From: [REDACTED]
Sent: 25 September 2025 10:33
To: Hebe Smith <Hebe.Smith@arun.gov.uk>
Subject: RE: Application FG/105/24/PL - Yeomans House, Littlehampton Road

Ferring Parish Council has no objection to the application, provided that the following two conditions are included:

Drawing No. G002-01 Rev.

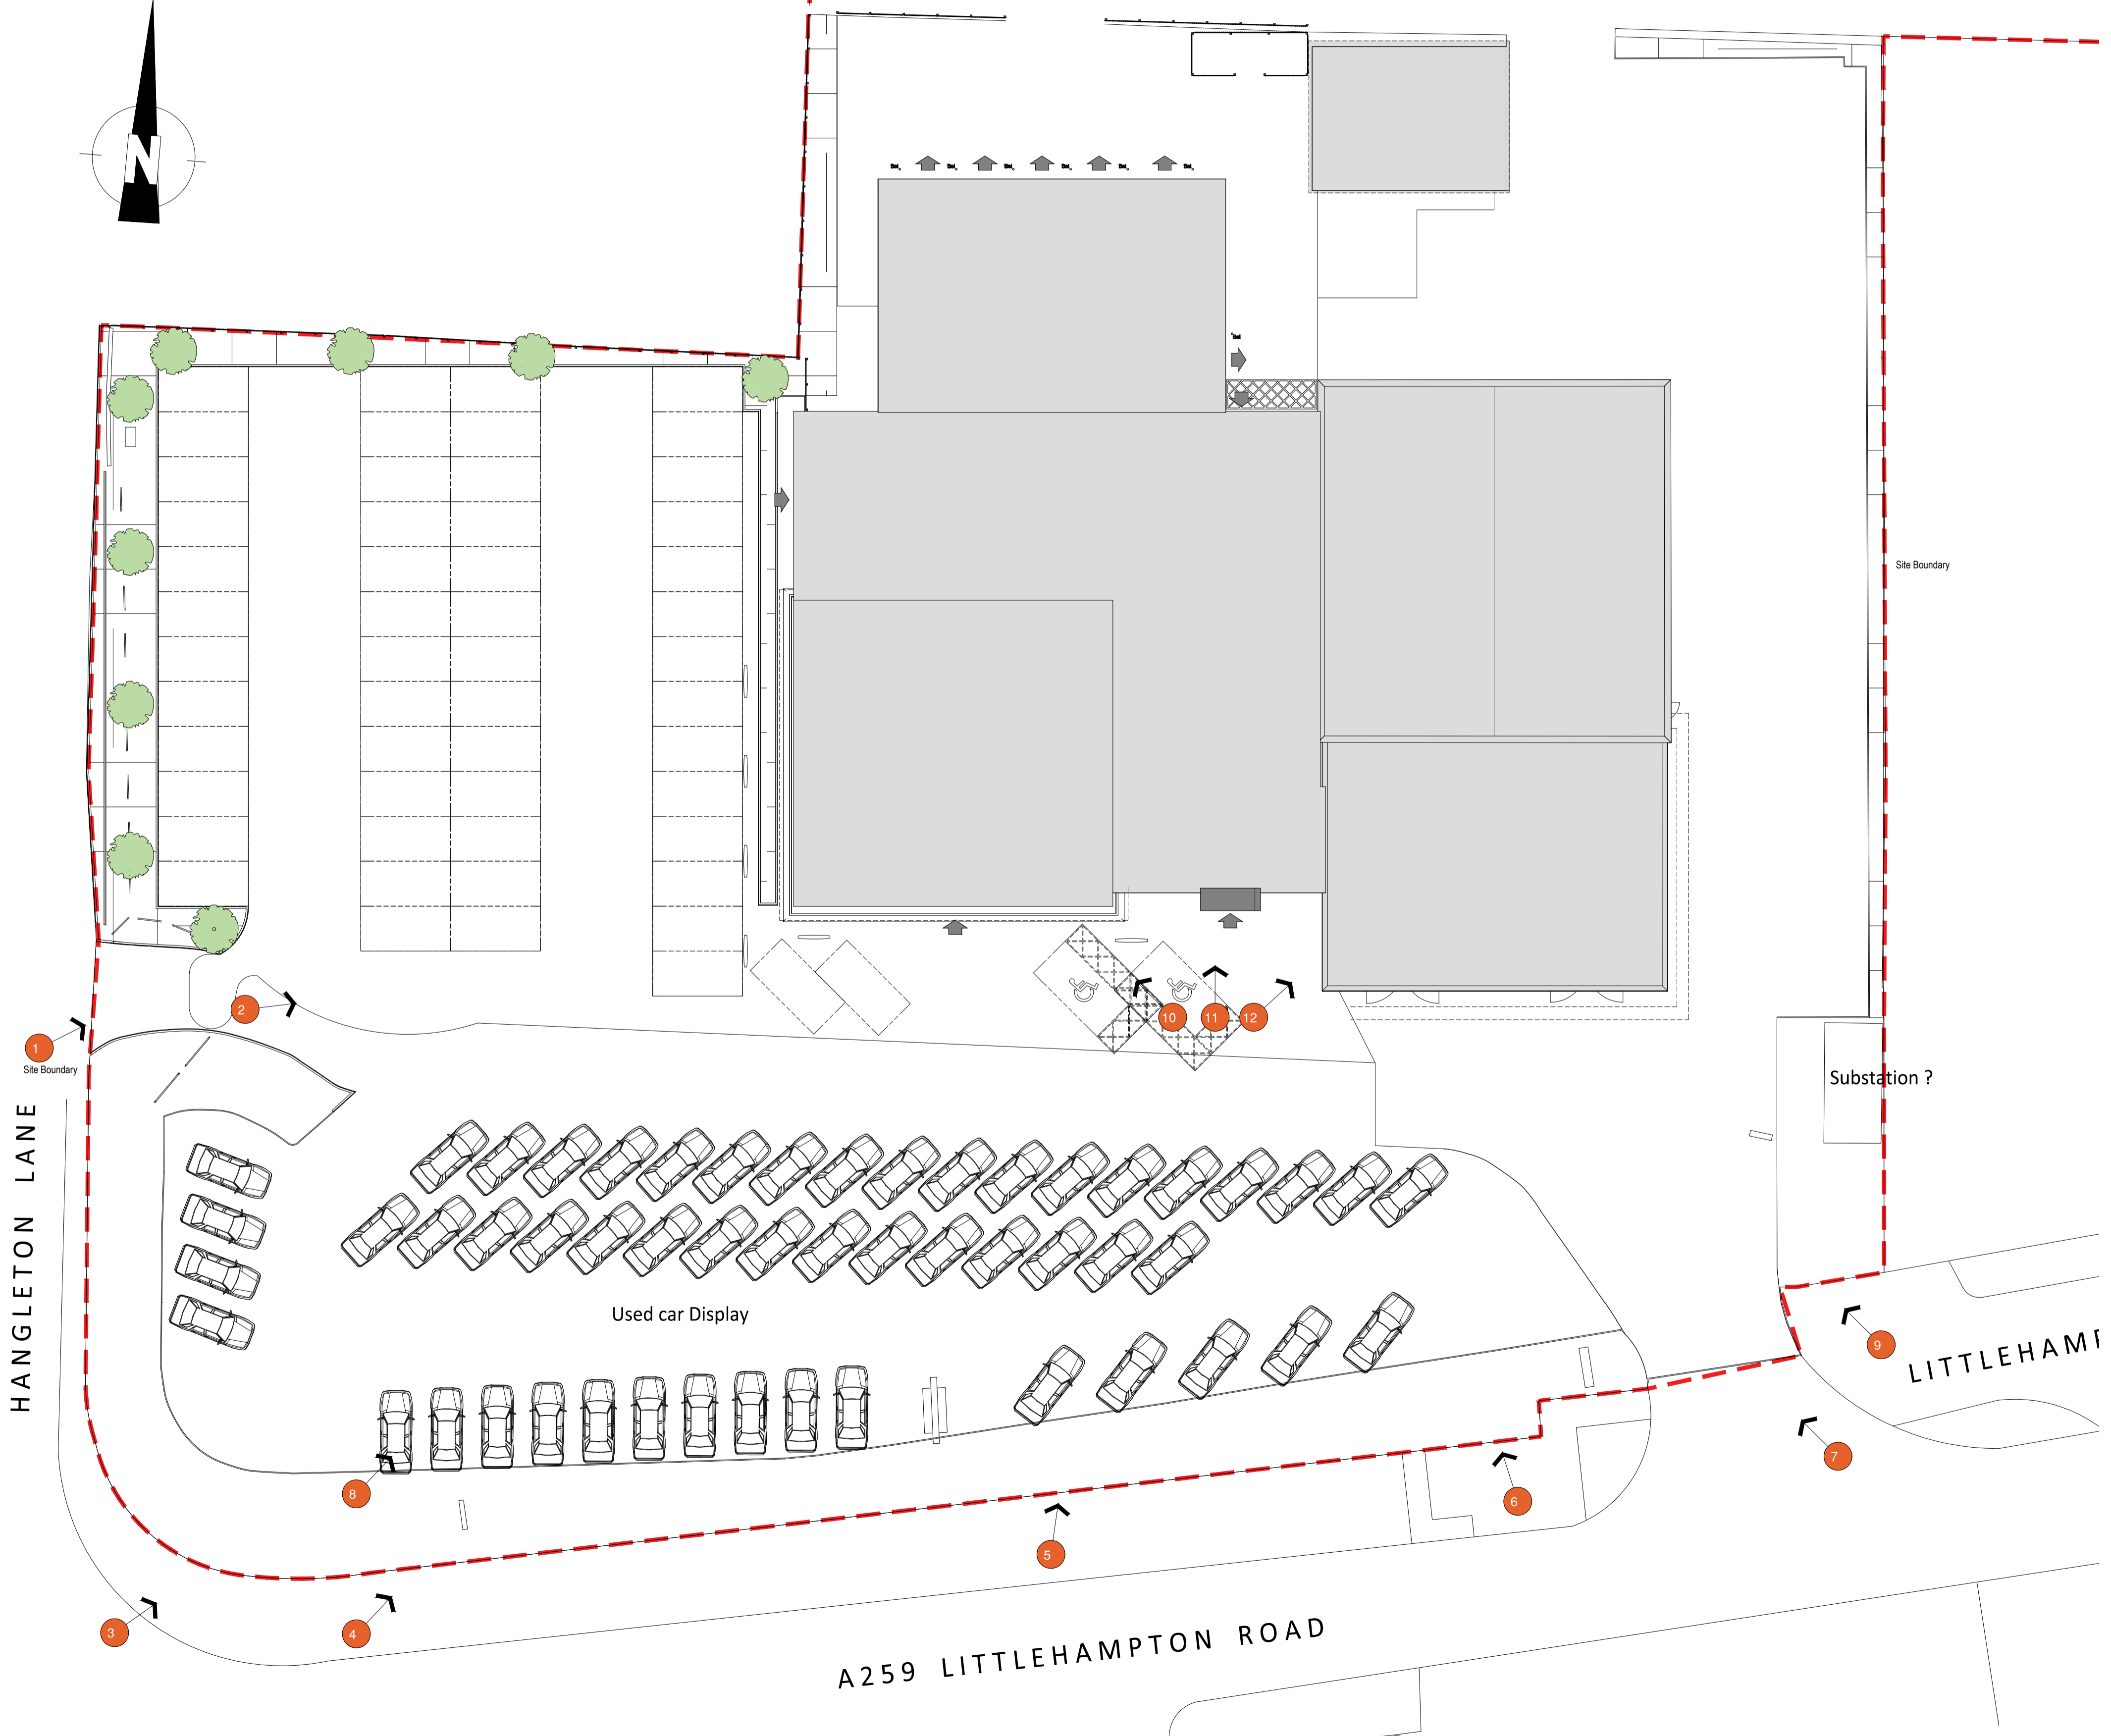
Disabled Parking Provision However, we note with concern that the existing site layout includes two disabled parking spaces, which appear to have been omitted in the proposed layout. In the interest of accessibility and compliance with equality legislation, we urge that the provision of disabled parking spaces be retained in the revised layout.
